**Addendum No. 1**

RE: Contract ID: C201628  
WBS# 37301  
Burke County  
SR-1419 (Bost Road) From NC-181 Intersection  
To North of SR-1421 (Lost Corner Road).

**August 15, 2006 Letting**

| 37301 | EC-4CONST.5 |

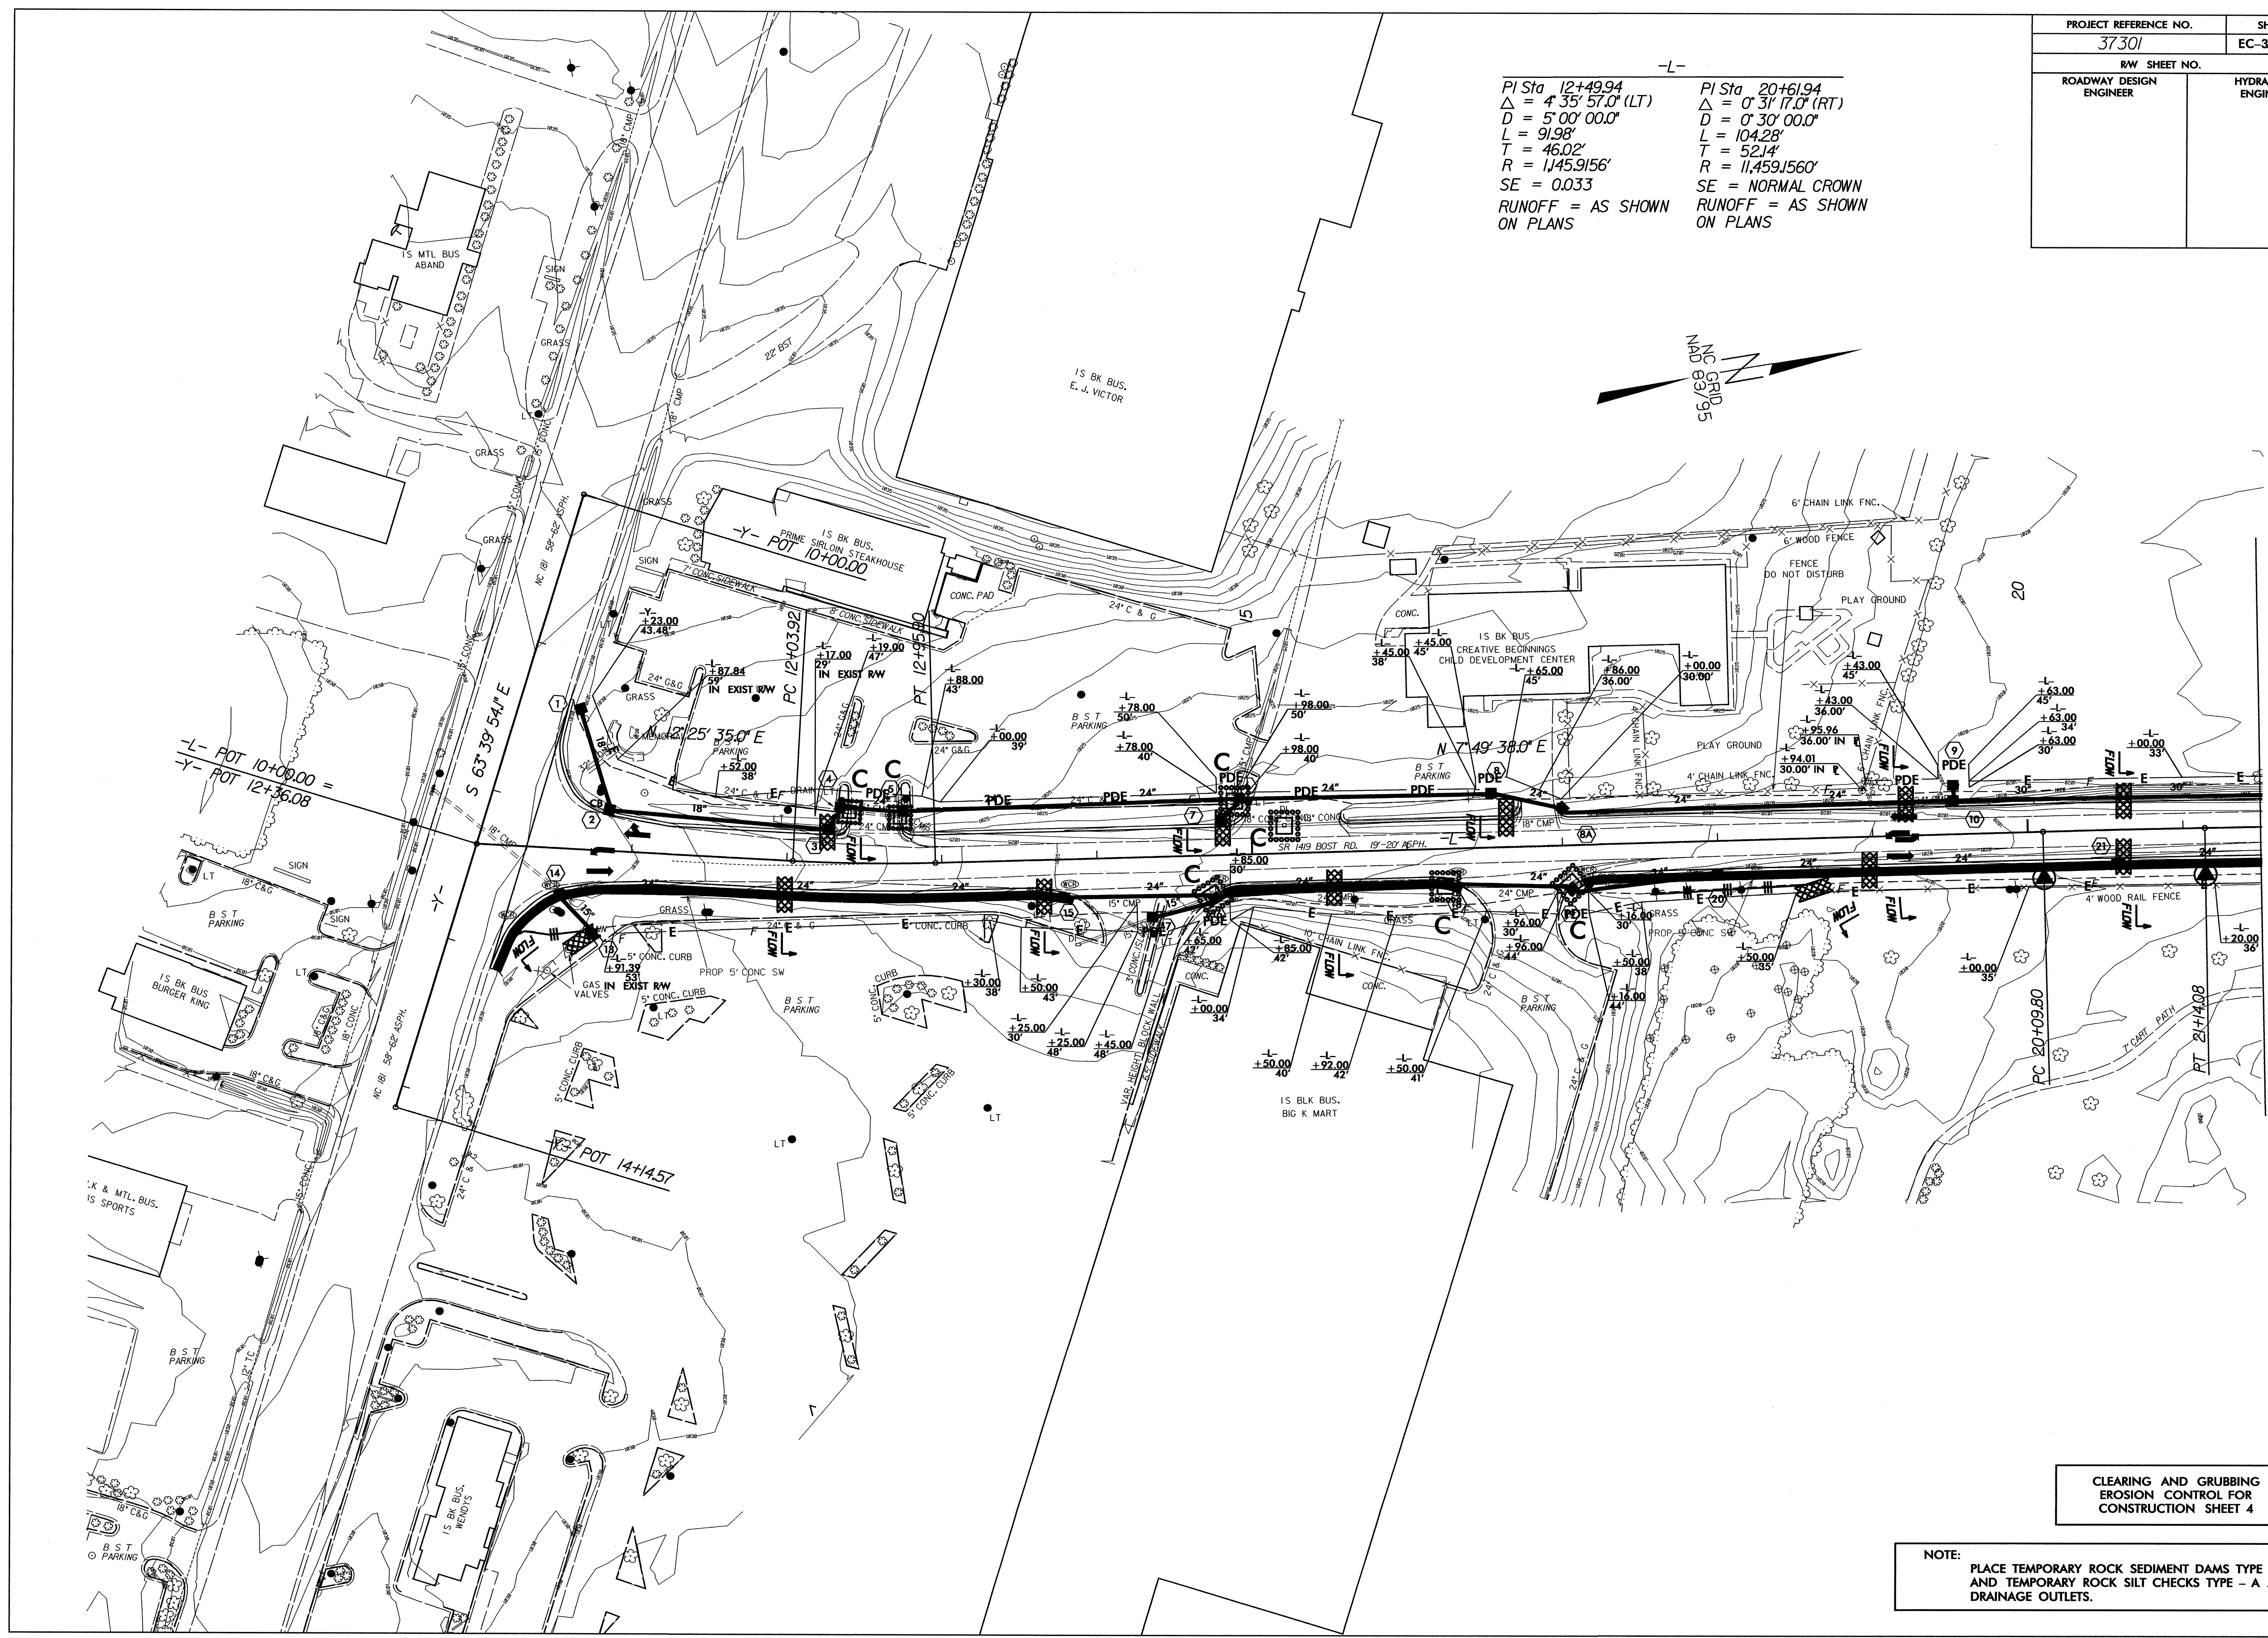
Sheet No. EC-4 has been revised to show "Pipe Construction Sequence" in four phases instead of two. Please void Sheet No. EC-4 in your plans and staple the revised Sheet No. EC-4 thereto.
